FINAL DRAINAGE REPORT
for
WINDERMERE FILING NO. 1

SF-21-026

**PCD-ENGINEERING REVIEW COMMENTS
IN BLUE BOXES WITH BLUE TEXT**

**EPC STORMWATER REVIEW COMMENTS ARE
SHOWN IN ORANGE BOXES WITH BLACK TEXT**

NORTH POND  
FINAL  
OUTLET DETAILS

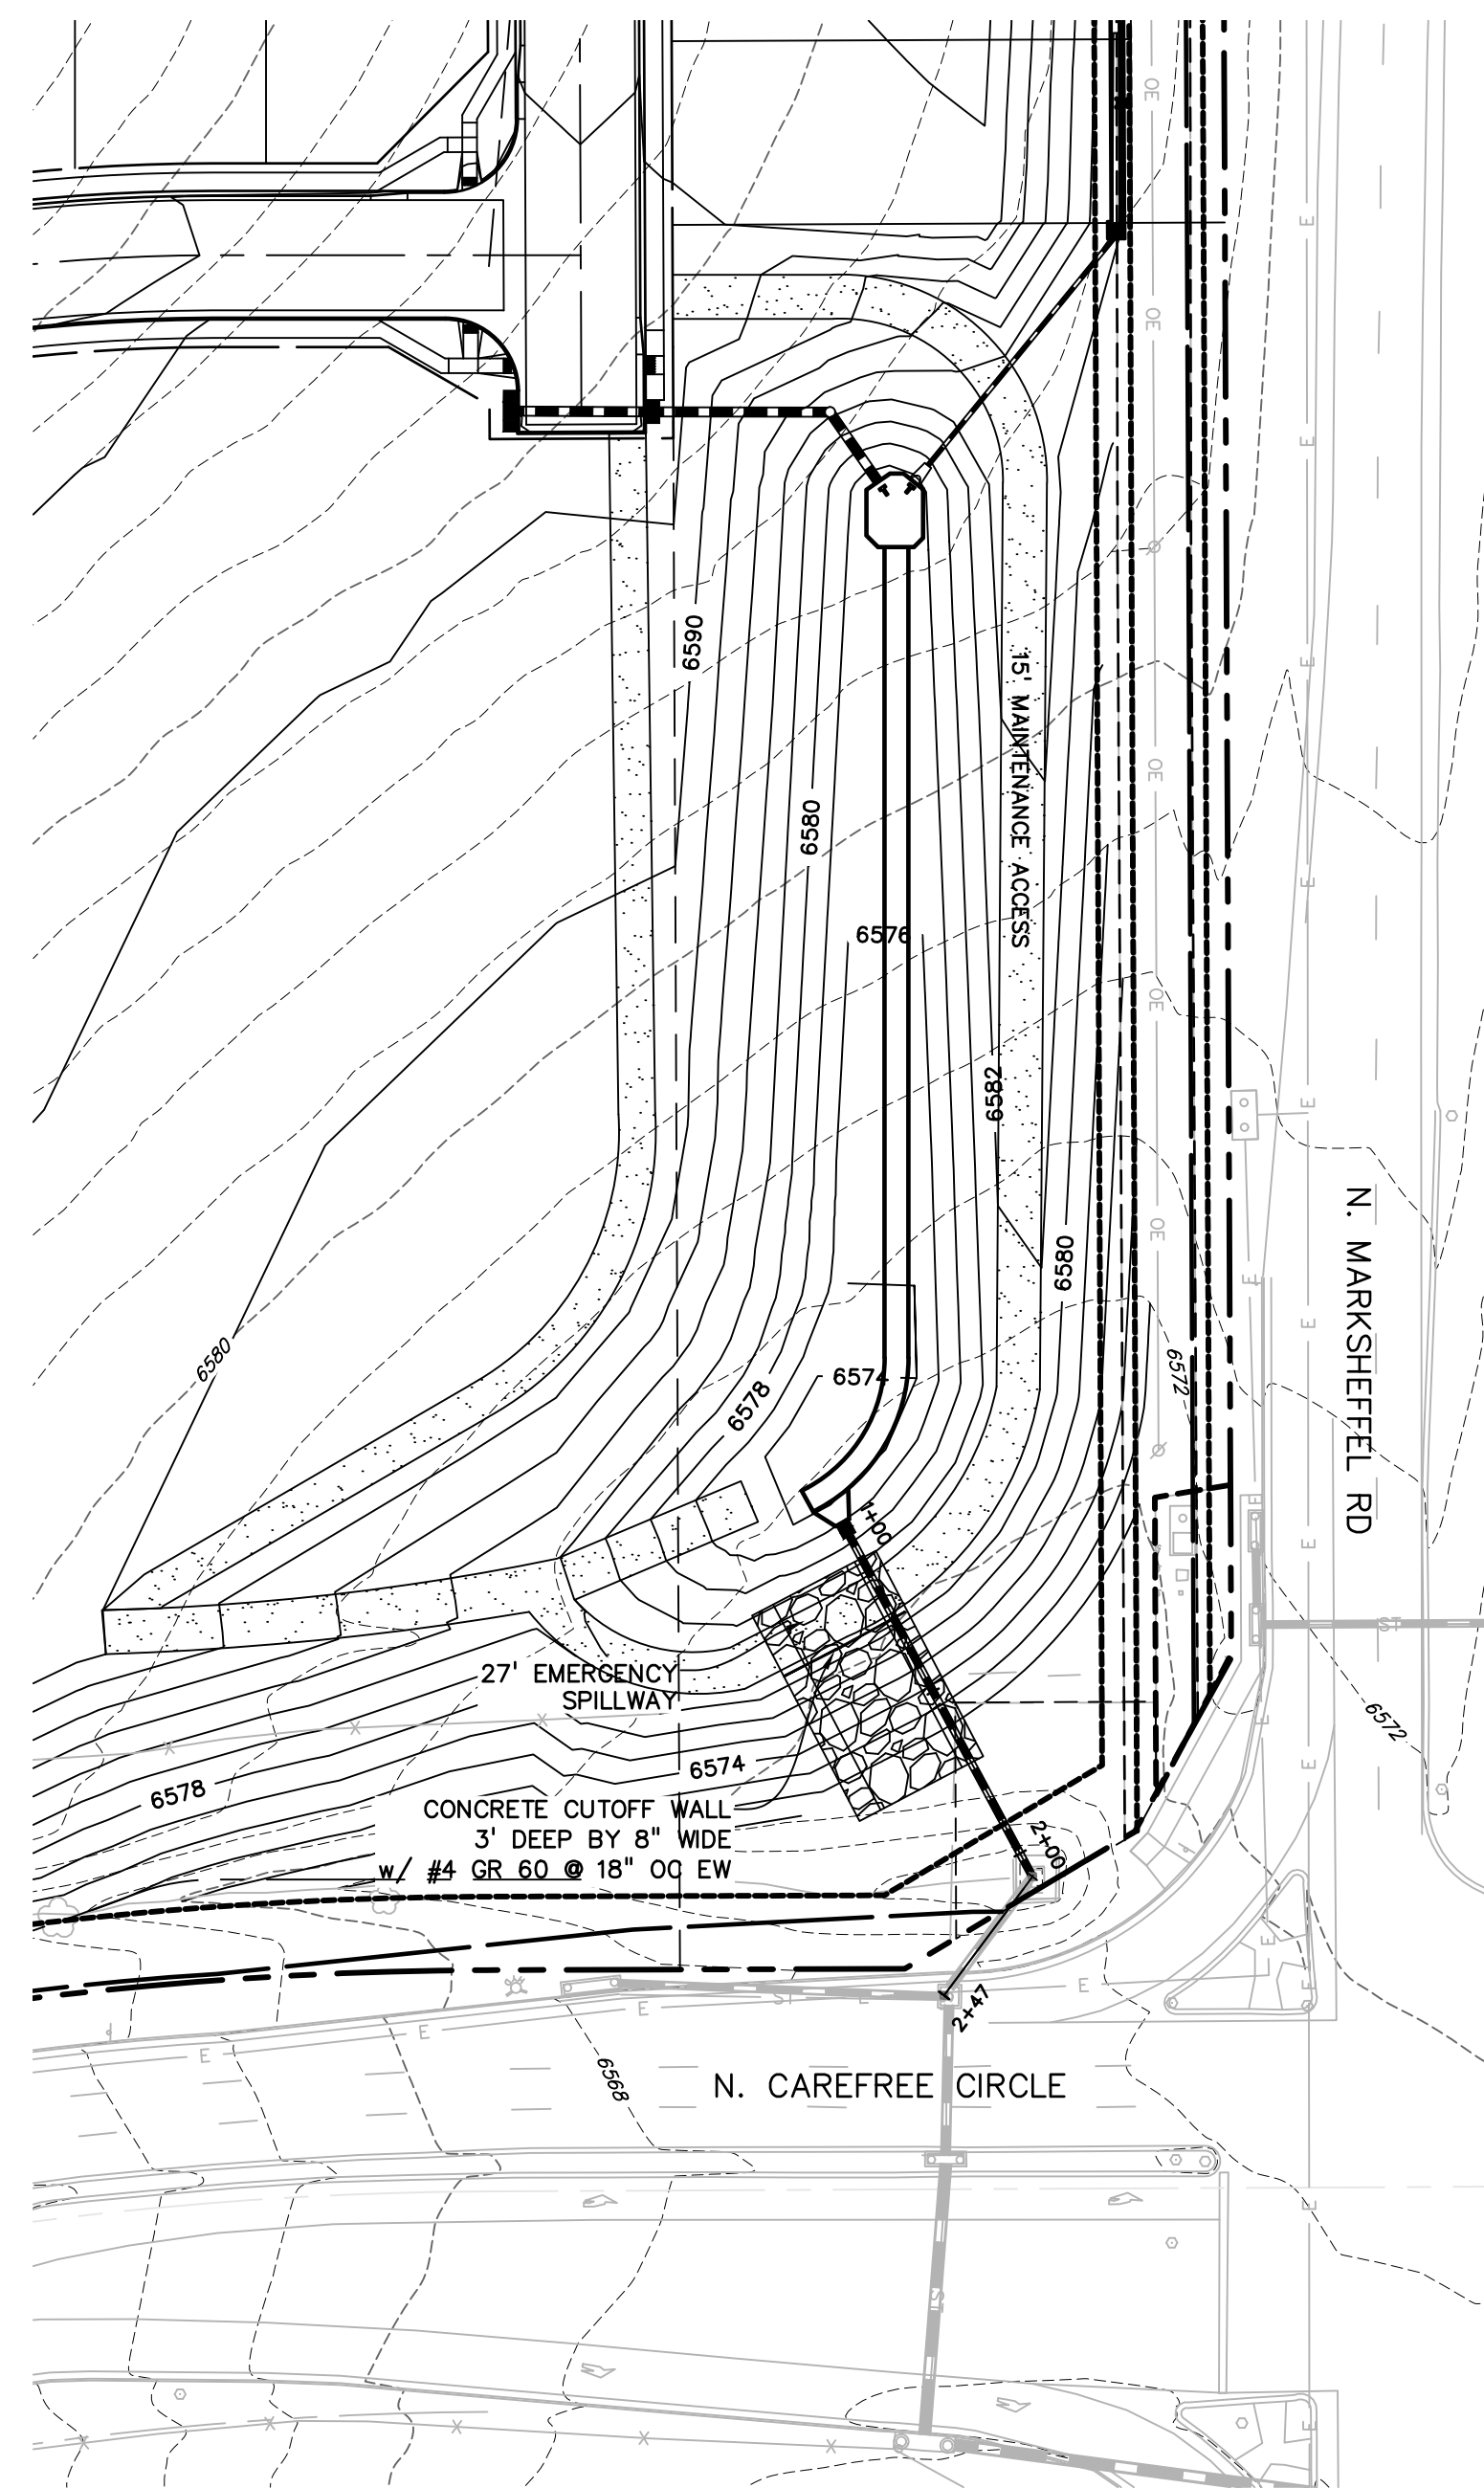
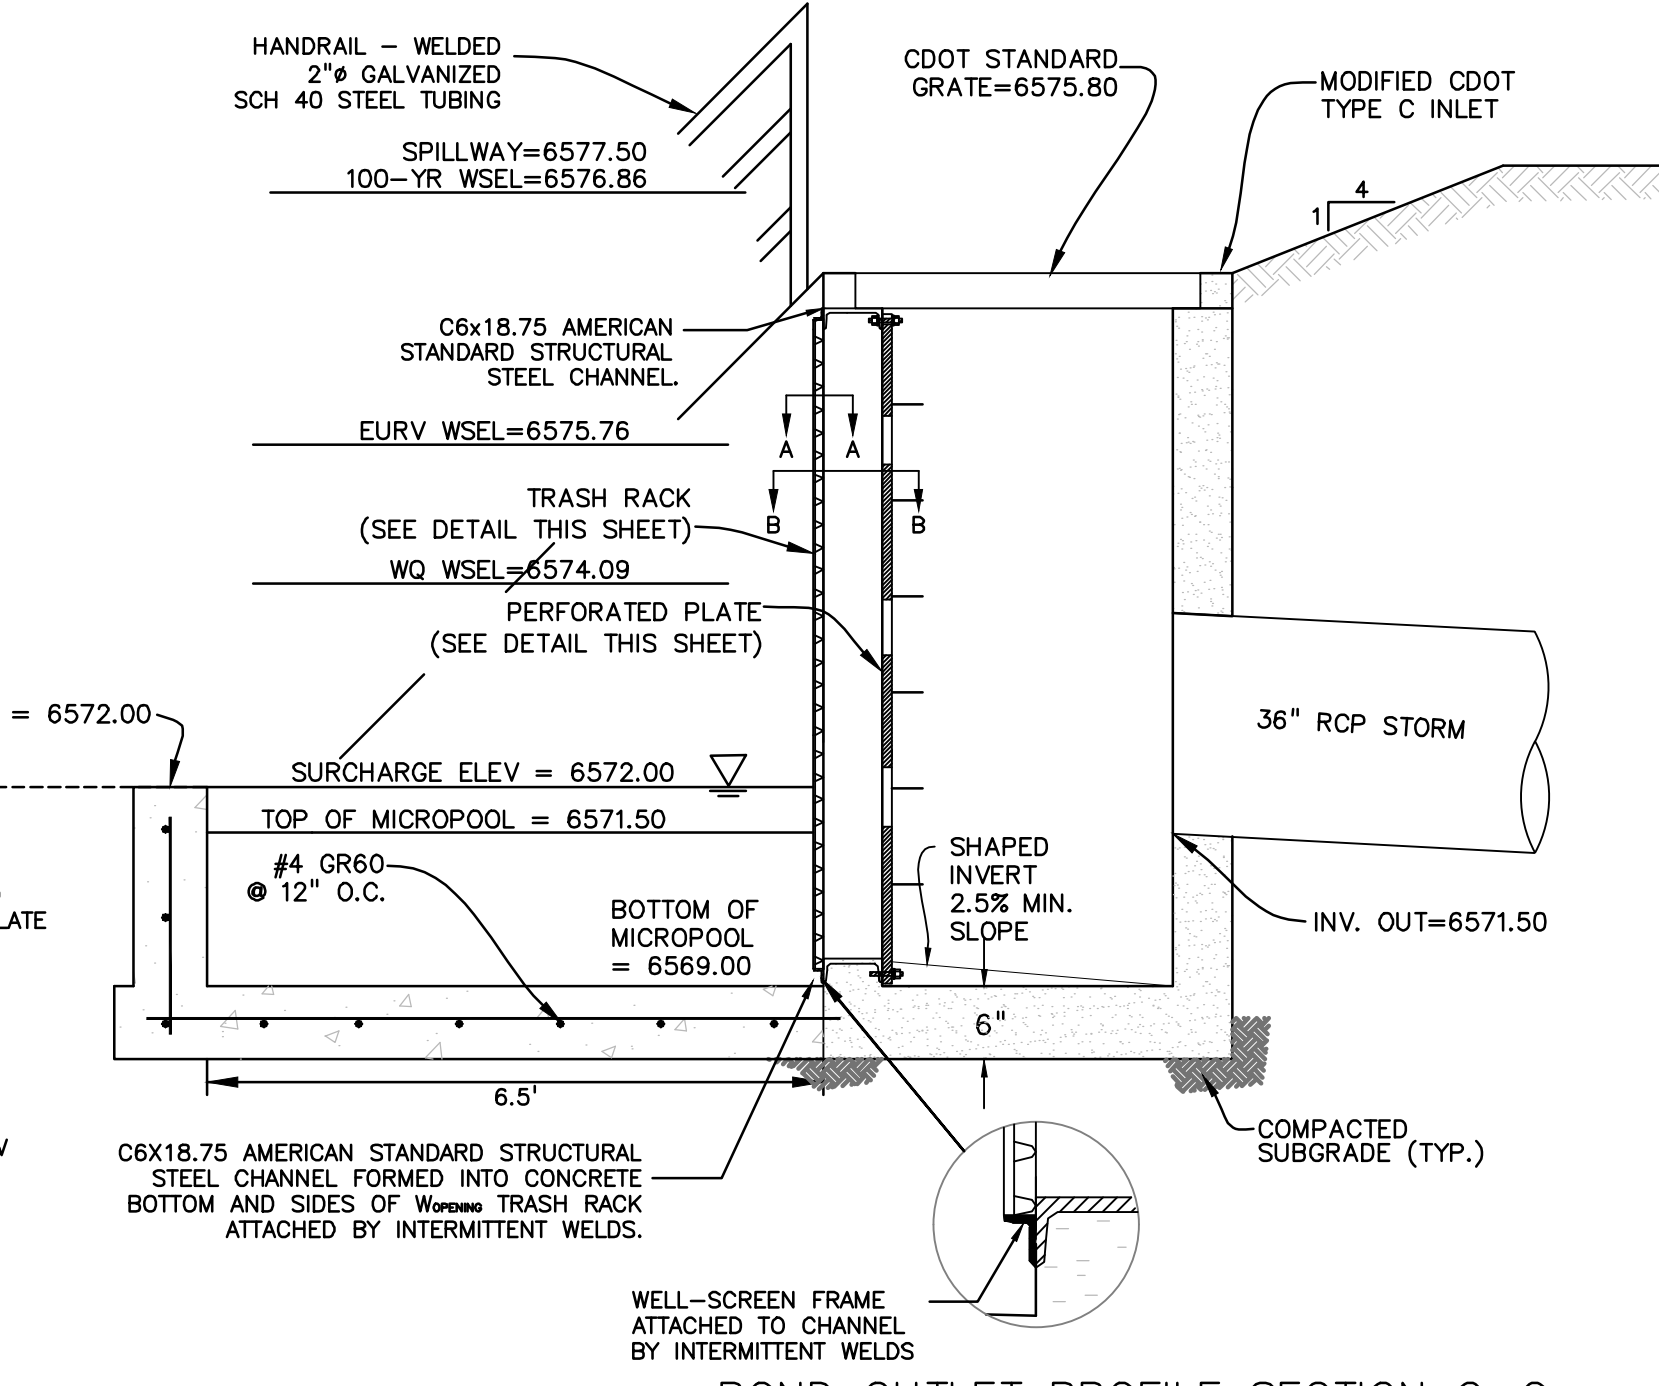
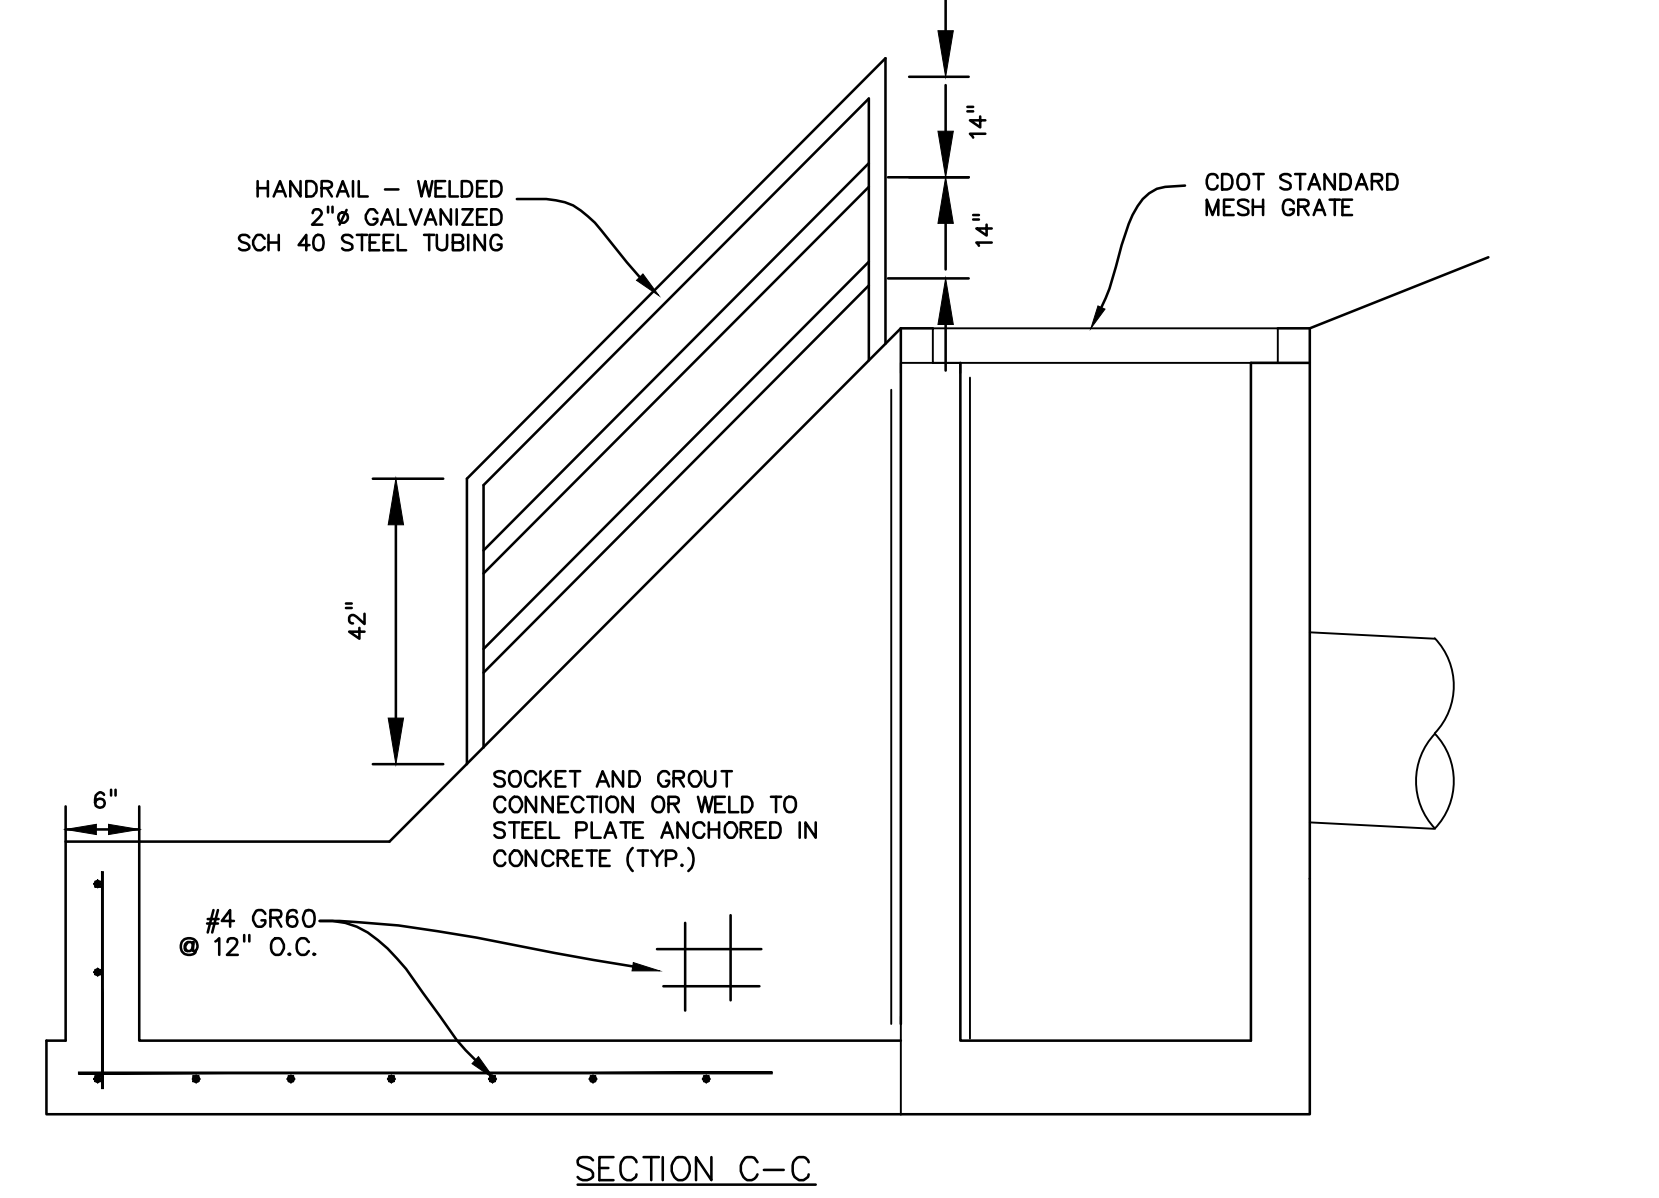
address capacity per comment letter. Is the development decreasing flows at this culvert? Provide the existing and developed flows for comparison.

I don't think we need the interim any more
